From: Sarah Burrow <Sarah.Burrow@arun.gov.uk>
Sent: 22 February 2022 13:59
To: Planning.Responses <Planning.Responses@arun.gov.uk>
Cc: Kathryn Welch <Kathryn.Welch@arun.gov.uk>
Subject: RE: Planning Consultation on: M/6/22/PL

Engineers Comments Regarding Surface Water Drainage

Application No: M/6/22/PL
Registered: 24th January 2022
Site Address: 88 Ancton Way Elmer Middleton-On-Sea PO22 6JP
Grid Reference: 498836 100377
Description of Works: Demolition of existing bungalow and erection of 1 No 2-storey, 4-bedroom detached house with 3 No off road car parking spaces. This site is in CIL Zone 4 and is CIL Liable as new dwelling.

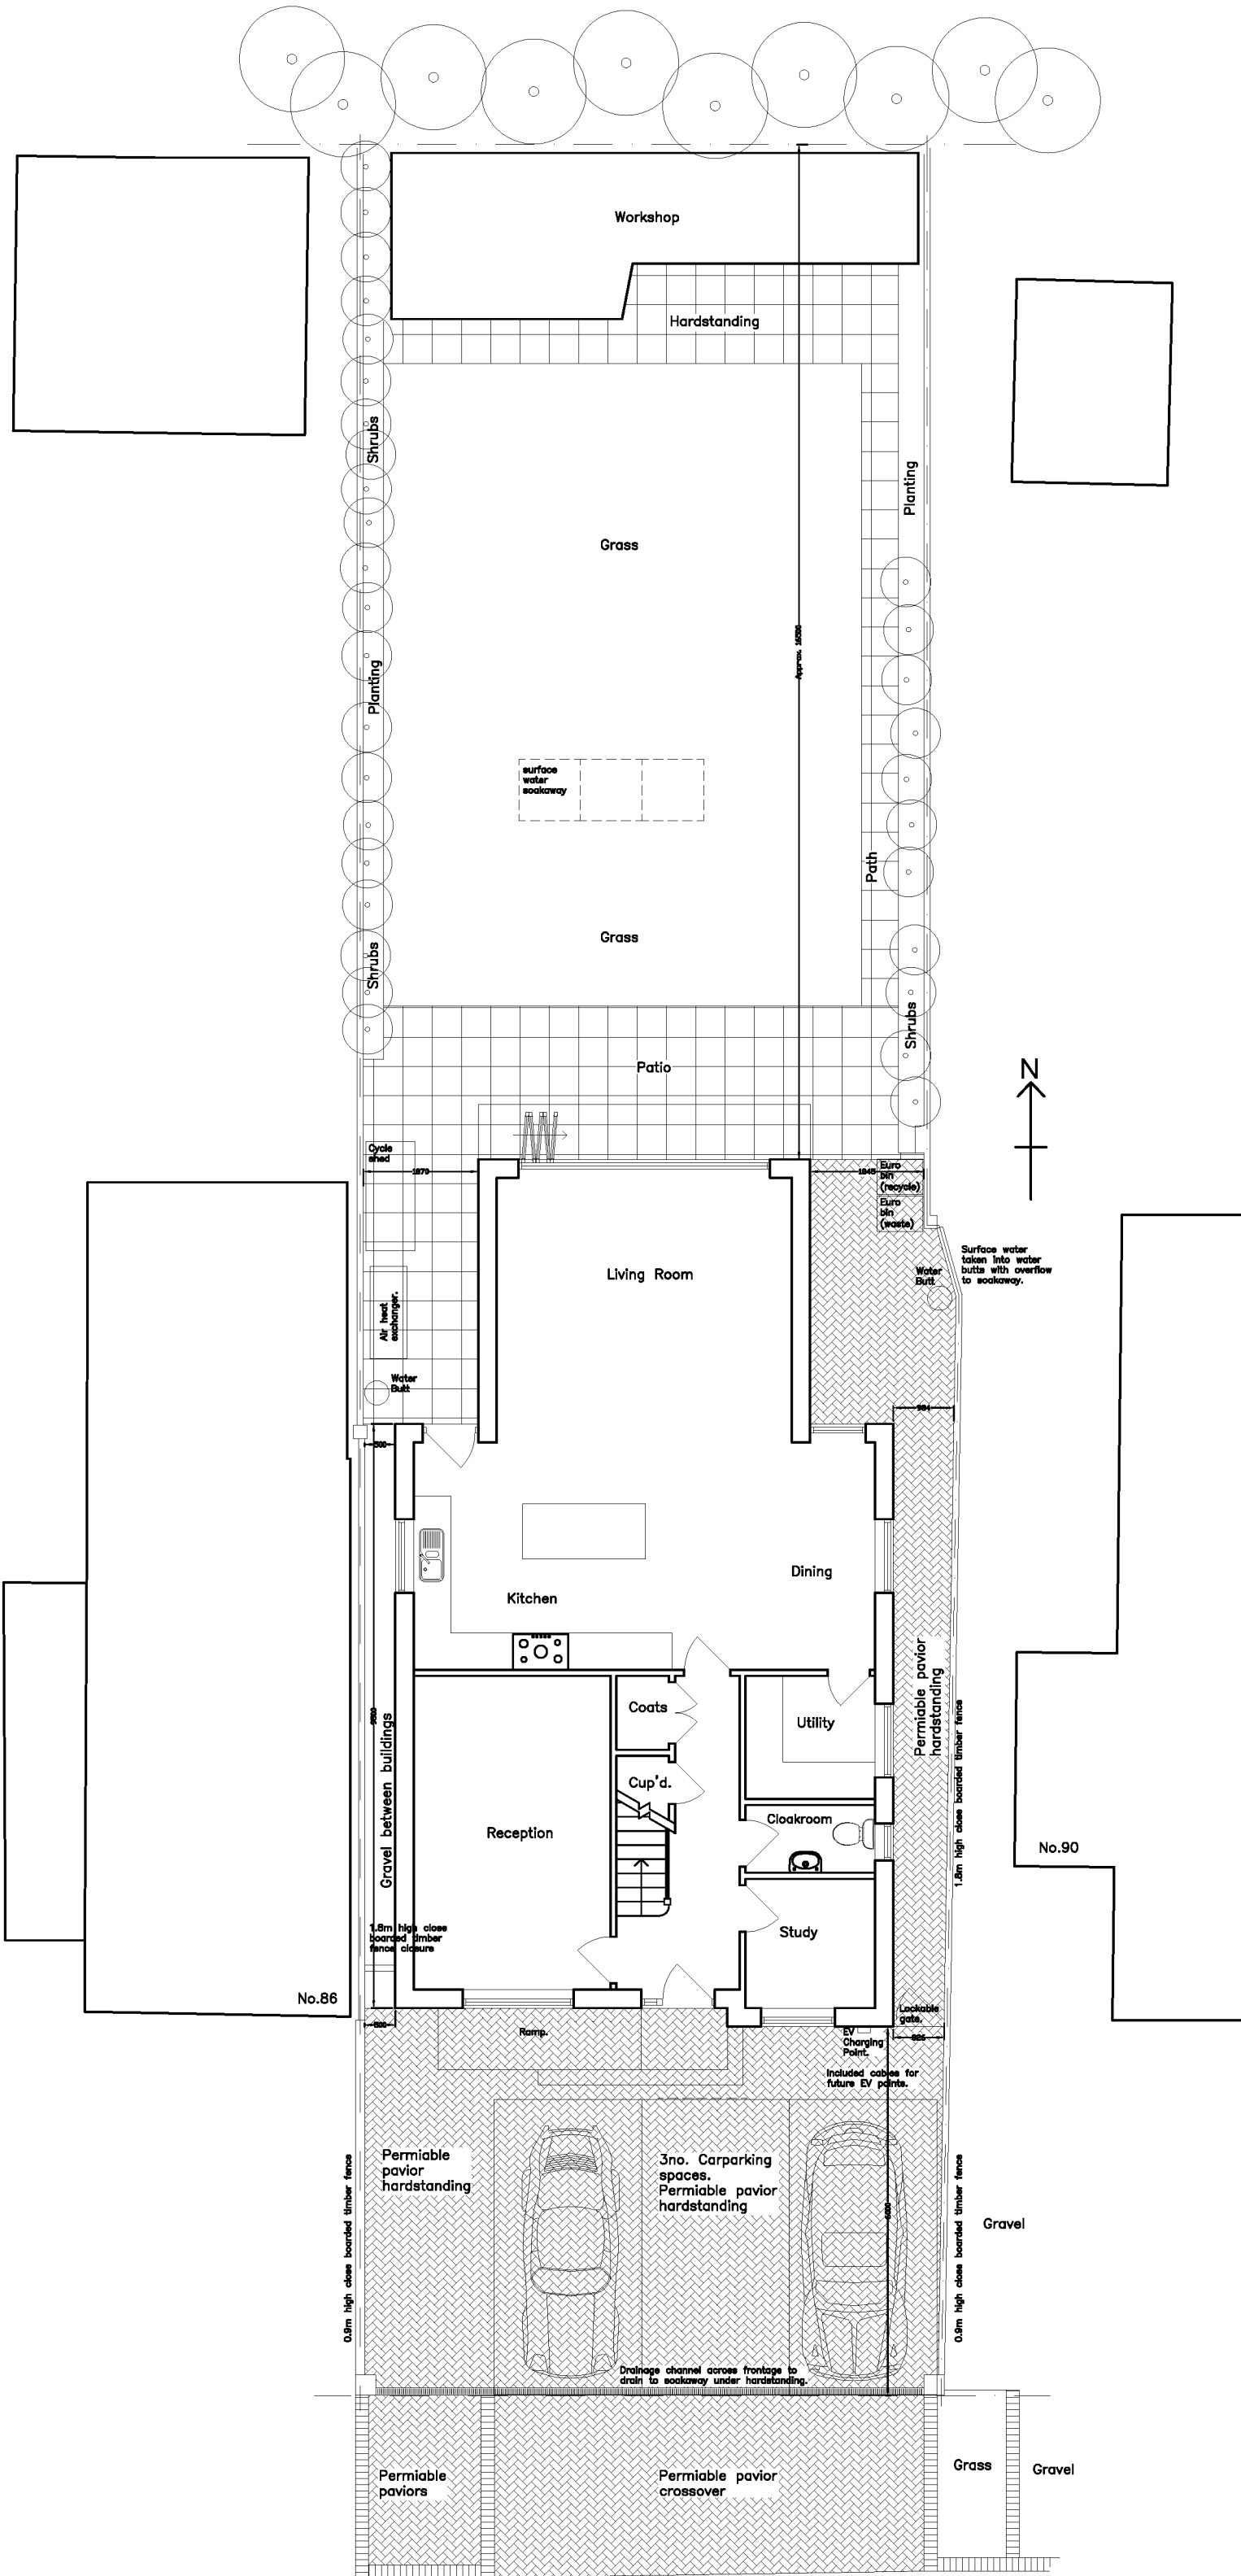
No surface water drainage design has been submitted with this application. The applicant has indicated an intention to drain surface water via soakaway, this must be located **5m** from the building. If infiltration is found to not be viable then there are few alternative options to drain surface water from the site. We will not support a proposed connection of surface water to the foul sewer under any circumstances if this is the case.

If you are minded to approve this application please apply standard condition PCENG2 to ensure that the development is adequately drained and does not increase flood risk elsewhere.

“Development shall not commence, other than works of site survey and investigation, until full details of the proposed surface water drainage scheme have been submitted to and approved in writing by the Local Planning Authority. The design should follow the hierarchy of preference for different types of surface water drainage disposal systems as set out in Approved Document H of the Building Regulations, and the recommendations of the SuDS Manual produced by CIRIA. Winter groundwater monitoring to establish highest annual ground water levels and winter Percolation testing to BRE 365, or similar approved, will be required to support the design of any Infiltration
